# Rezoning Transportation Analysis

Petition Number: 2024-027

Date	Description
3-27-24	First Review (NK)
4-24-24	Second Review (NK)

The petition is located adjacent to Pierson Drive, a City-maintained local street, south of Independence Boulevard, a State-maintained expressway. The petition is located in a southeast corridor outside of Route 4, within the Independence Boulevard Area Plan.

REZONING SITE PLAN

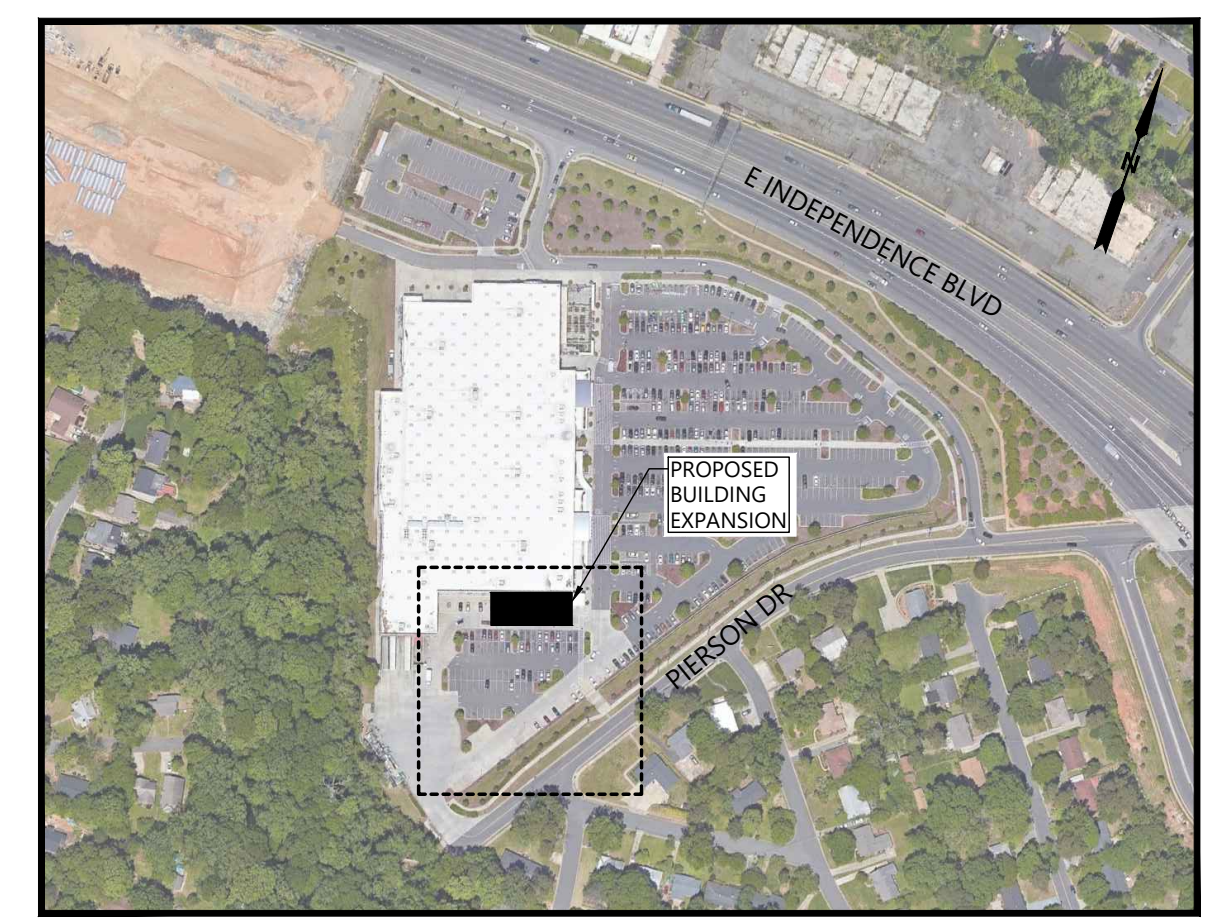
**Clarifying Comment 4.24.24:** The current ROW does not completely encapsulate the existing sidewalk. The ROW must come to the back of the existing sidewalk and either ROW or SUE need to extend 2' out from the back of the sidewalk.

7. Add a conditional note specifying "the Petitioner shall dedicate and convey in fee simple all rights-of-way to the City before the site's first building certificate of occupancy is issued. CDOT requests rights-of-way set at 2' behind back of sidewalk where feasible."
